NSW GOVERNMENT
Department of Planning

NSW GOVERNMENT
Department of Natural Resources

Re: 72 lot subdivision – Manyana Drive Manyana

The above proposal has been reviewed by both the Department of Planning as well as the Department of Natural Resources, South Coast regions and the following comments are provided.

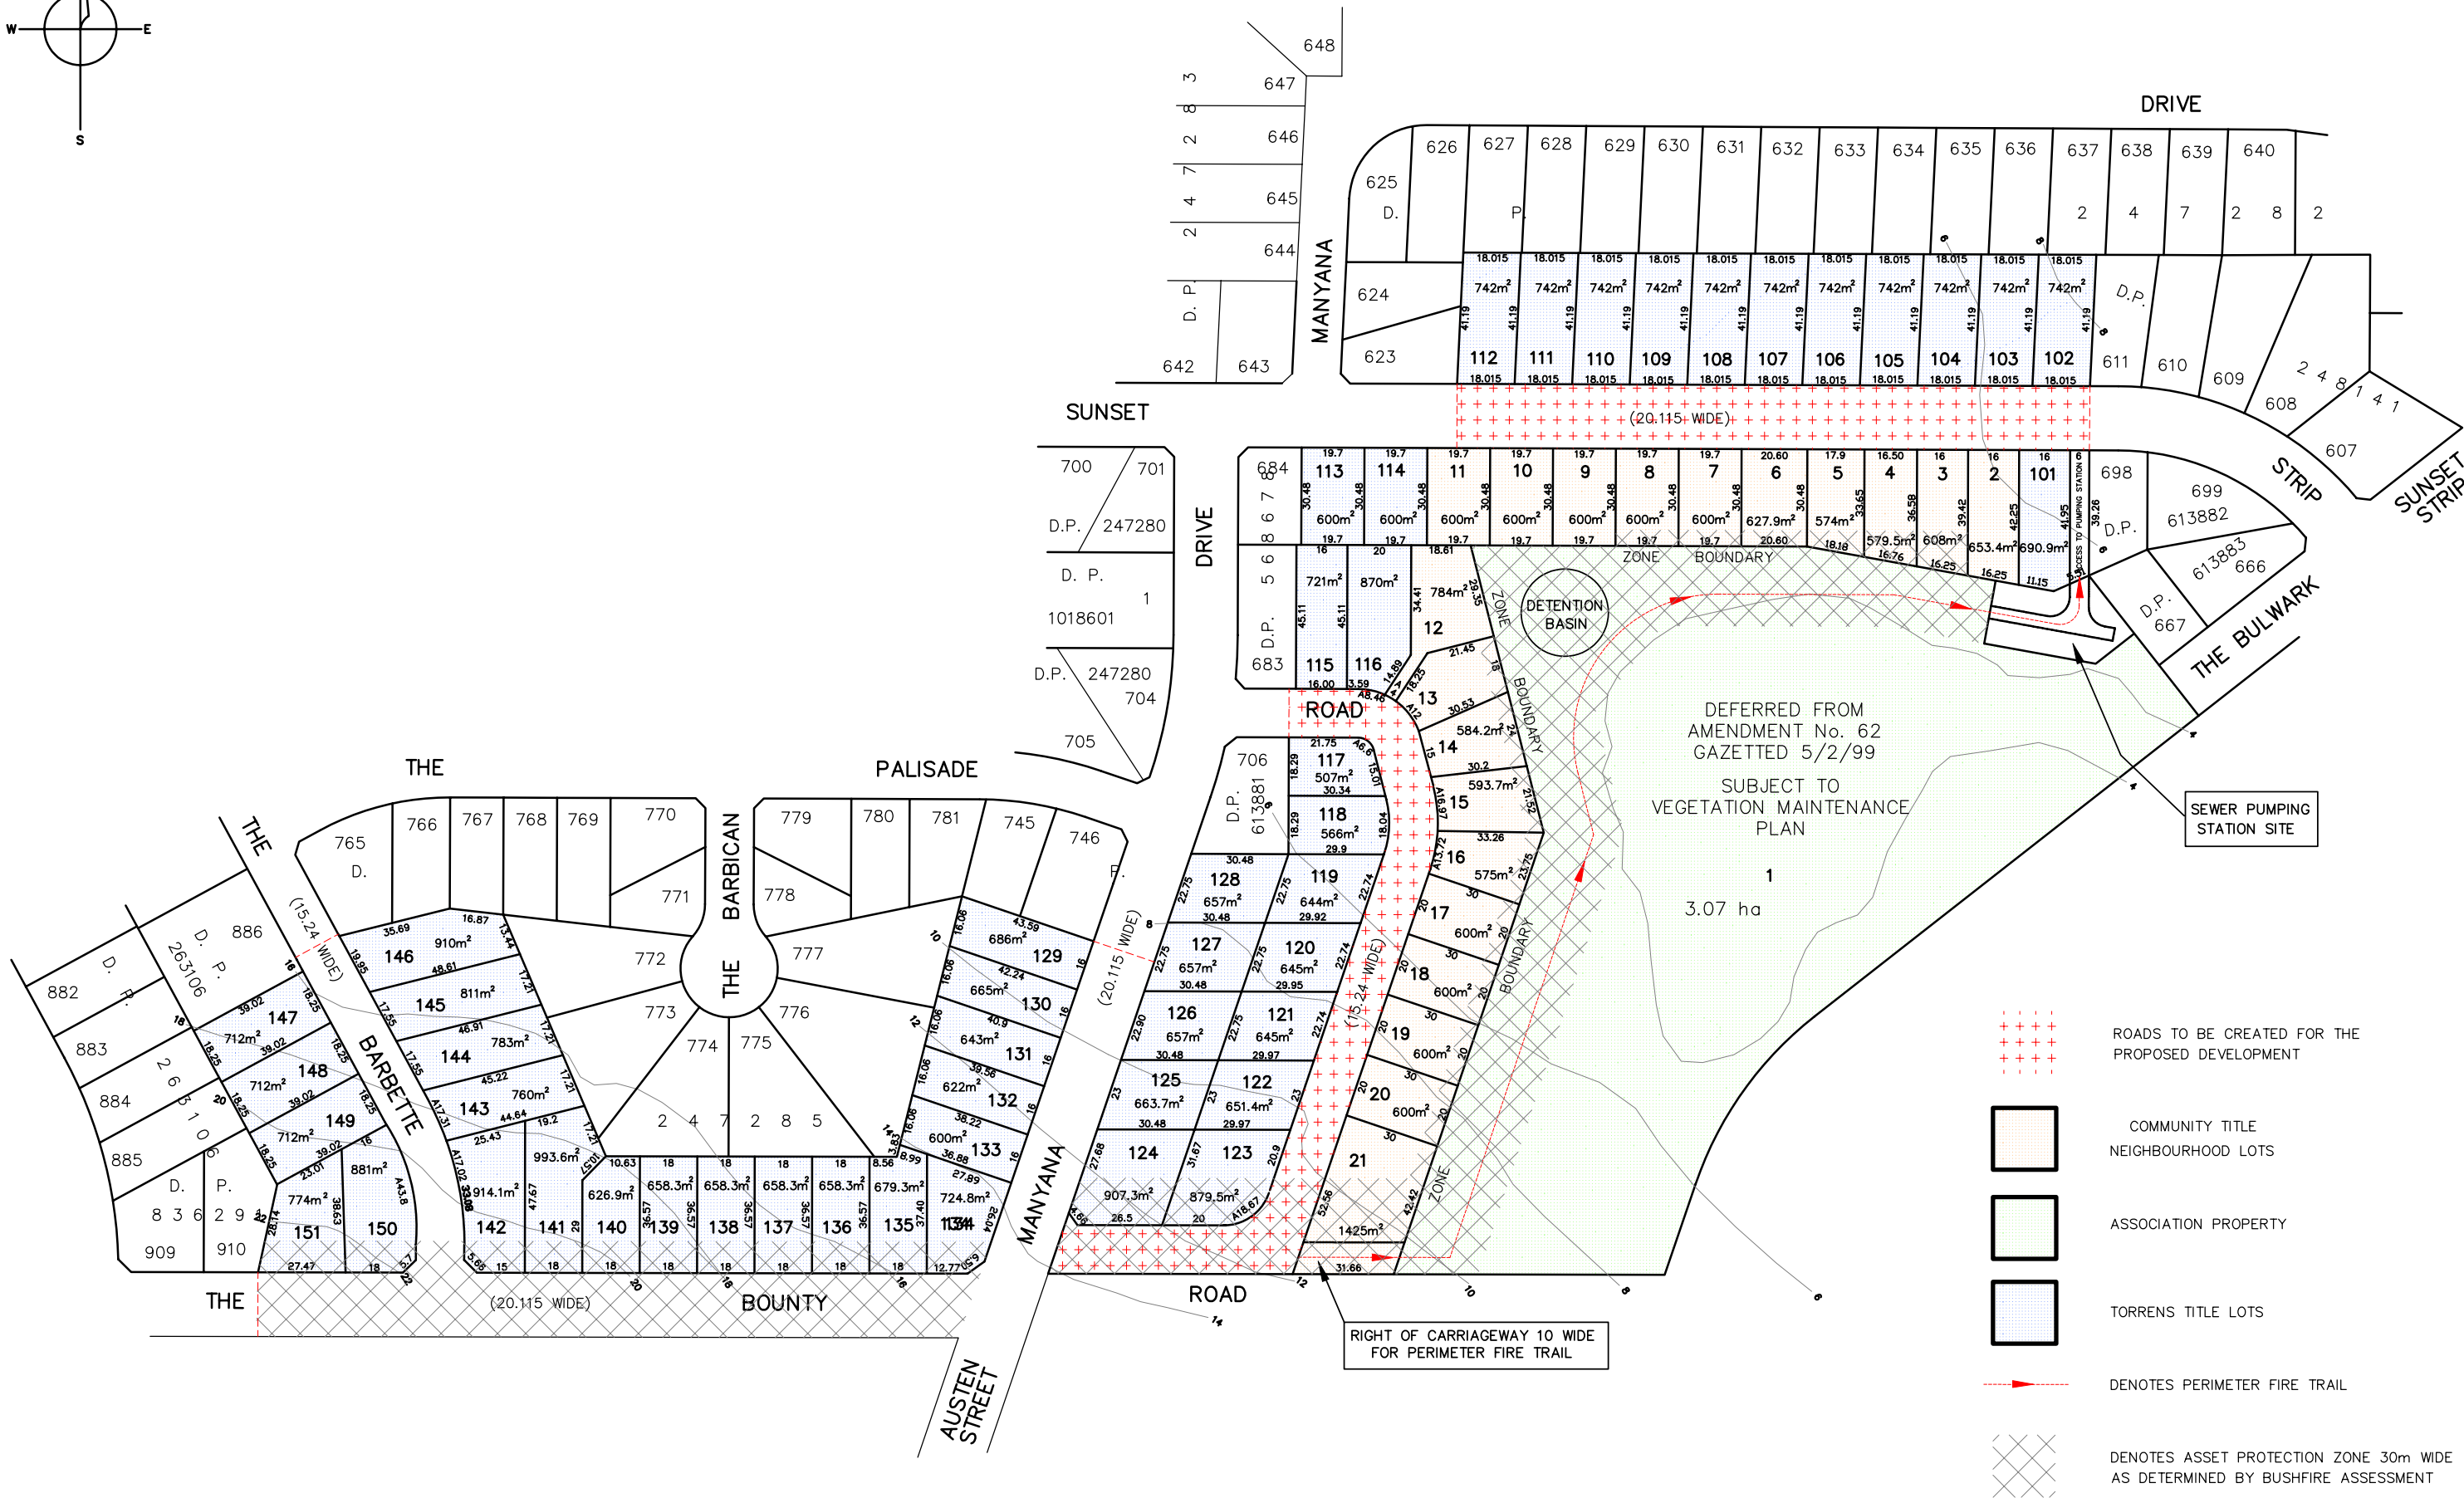
As a result of the above categorisation, the lots proposed in the vicinity of the watercourse should be reviewed to ensure that riparian management outcomes are achieved. It appears that the Community Title Lots (2-15 particularly) and their associated APZ's may conflict with these recommended riparian management objectives. ^{resulting in}

DIPNR has specific concerns with proposed lots 2-22 (Community Title Neighbourhood Lots) and their associated APZ. The issues outlined above also have consequences for Lots 101, 113-116 and 117-119. With the exception of clearing some vegetation, all other lots appear to have minimal constraints.

Ideally the area proposed to be developed into residential lots should be flanked by perimeter roads separating lots to be developed from bushland areas and which can contribute to the bushfire asset protection requirements for the site. It is suggested that the preferred location of the perimeter road should correspond to the edge of all of the proposed Torrens title lots indicated. In this way the extent of vegetation loss and encroachments into the identified EEC for asset protection purposes can also be significantly reduced.

It is recommended that the lot layout and subdivision design be amended to reflecting the significant ecology of the EEC and the natural values of this area.

It is noted that the proposed titling scheme and lot layout contains a reference to a possible location for a detention basin but does not contain any provision for drainage easements or other legal mechanisms to provide unhindered flow paths to convey flows to or from the basin.
